From: Kerri Simpson
Sent: 26 March 2026 14:18
To: DC Admin
Subject: FW: 2025/62/93514/E Demolition of existing barns and erection of 4 detached dwellina

From:
Sent: 22 January 2026 14:58
To: Areas Planning <Areas.Planning@kirklees.gov.uk>; Planning Portal <Planning.Portal@kirklees.gov.uk>
Subject: 2025/62/93514/E Demolition of existing barns and erection of 4 detached dwelling
Importance: High

Application 2025/62/93514/E

Field Elevation 1: 100

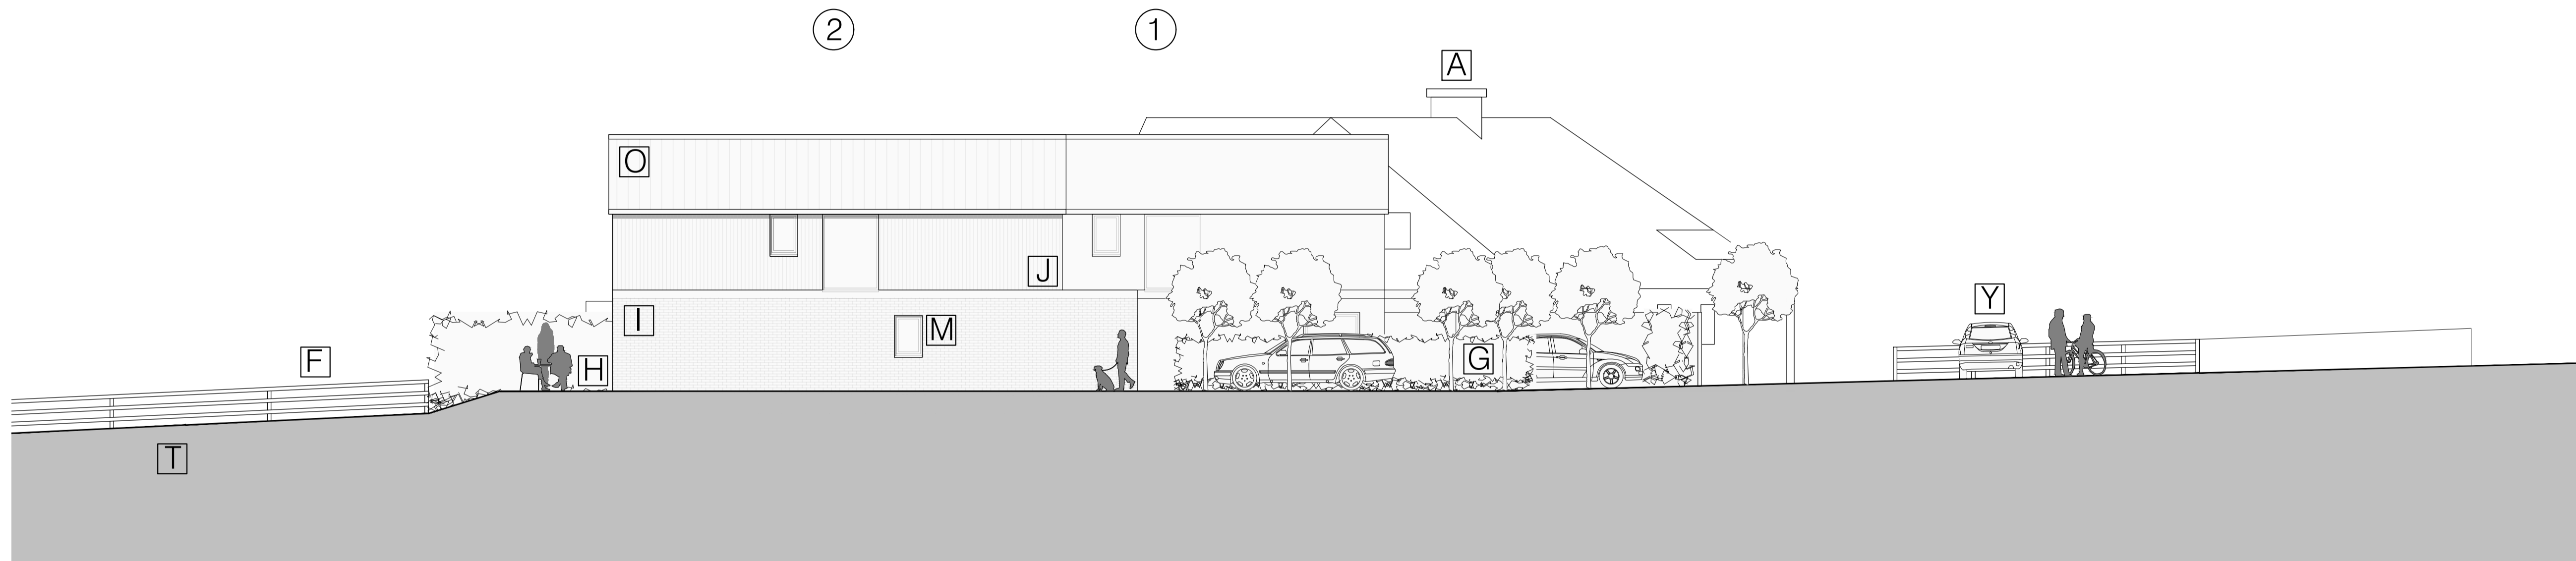
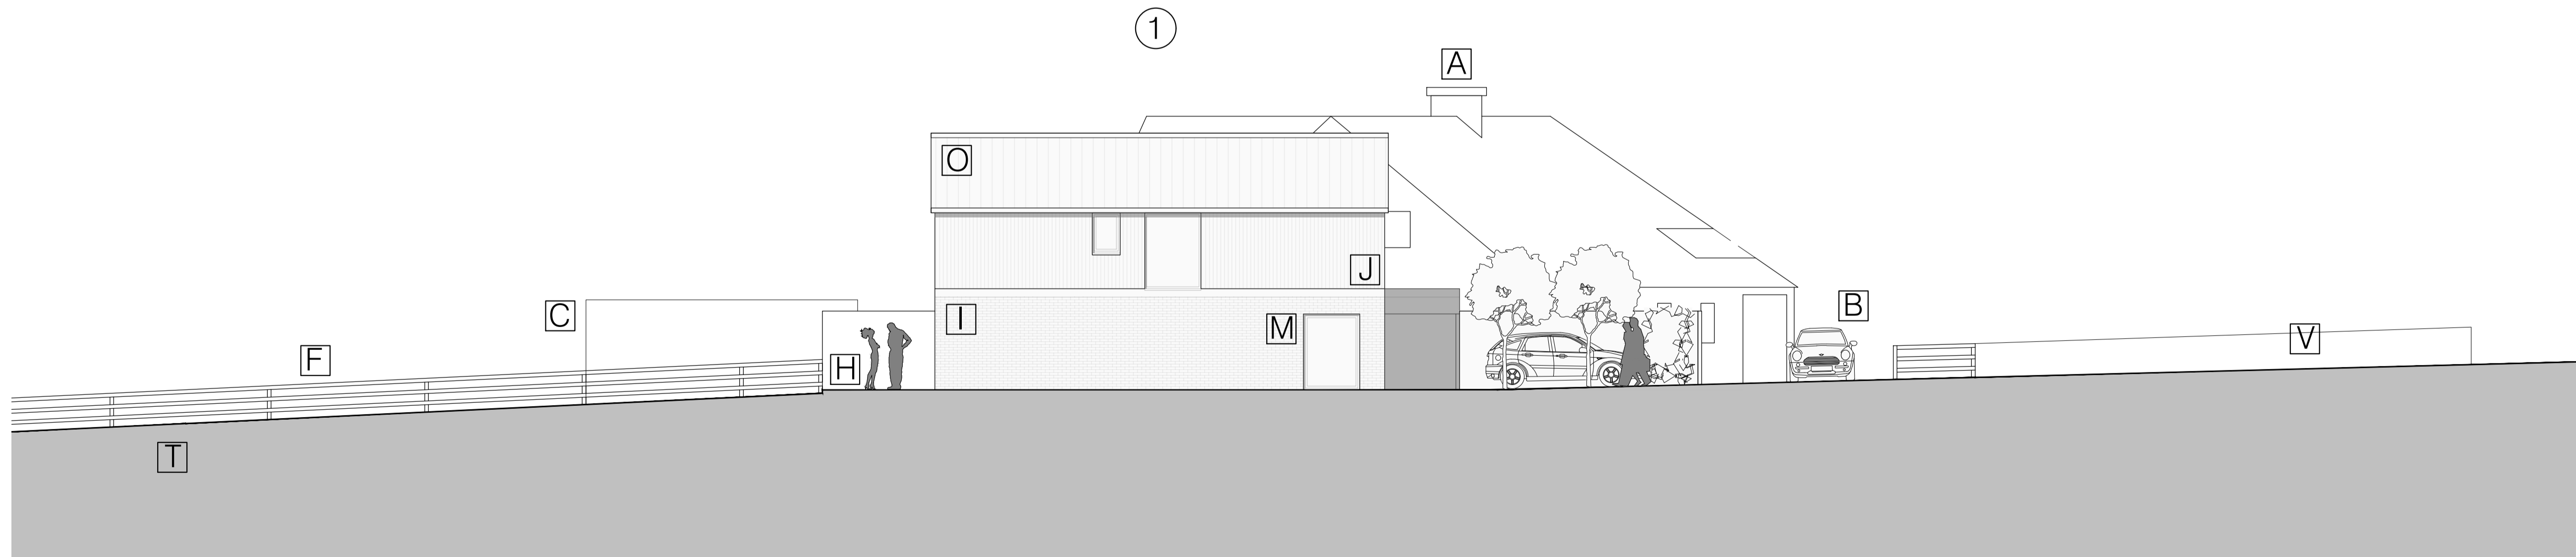
4. The new proposal is not in keeping with the existing farmhouse, or the character of visible rural agricultural surroundings, in respect of size, appearance, prominence, or building materials.
5. Consent to build on the site is required from the adjacent owner and this has not been obtained.
